Our Ref: N26754

**SHOALHAVEN STARCHES MODIFICATION 21  
COMMENTS FROM SHOALHAVEN CITY COUNCIL**

I refer to the email from Andre Vernez (Shoalhaven City Council) to Shaun Williams (Planning NSW) dated 3 March 2022 and respond as follows:

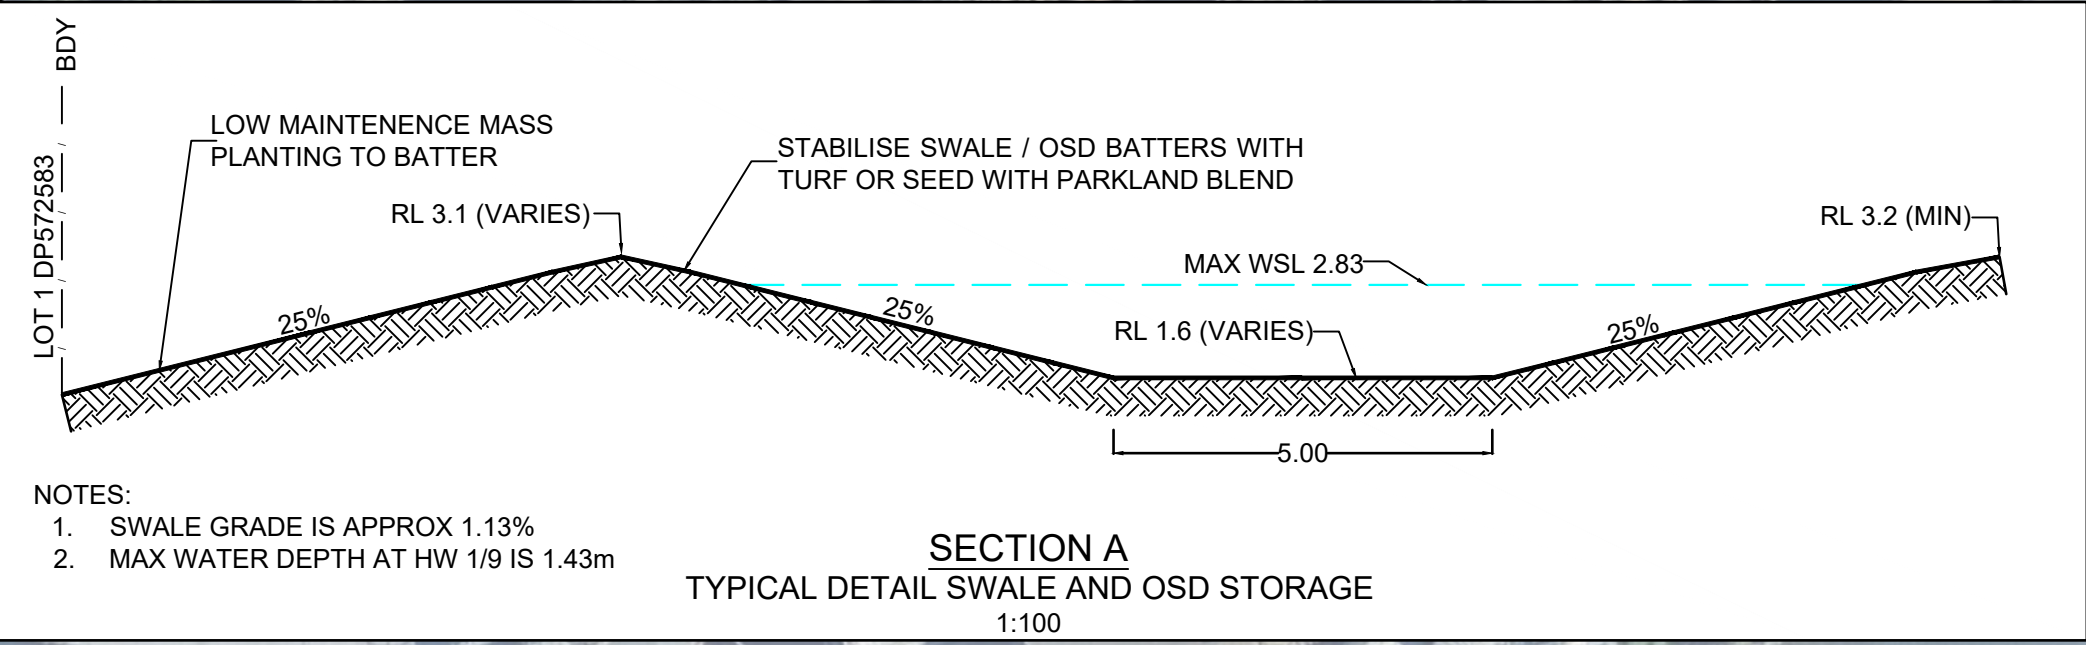
Drawing N26754 SK14-3 has been modified to include a typical section and depth of ponding.

Given the operational site will be strictly controlled to ensure that employees and visitors, and indeed trespassers, are not at liberty to wander over the site. An 'Out of Bounds' area is not unusual for a site of this nature.

Maintenance of the swale and OSD area will simply involve vegetation management using handheld mowers and/or edge trimmers. Simple vegetation management actions will be integrated into the overall maintenance plan and associated Safety Plan for the Packaging Plant precinct.

Drawing N26754 SK14-3 has been modified to include a pool type safety fence in order to comply prevent accidental entry into the OSD. That part of the OSD in which depth of water exceeds 0.3 m will be fenced.
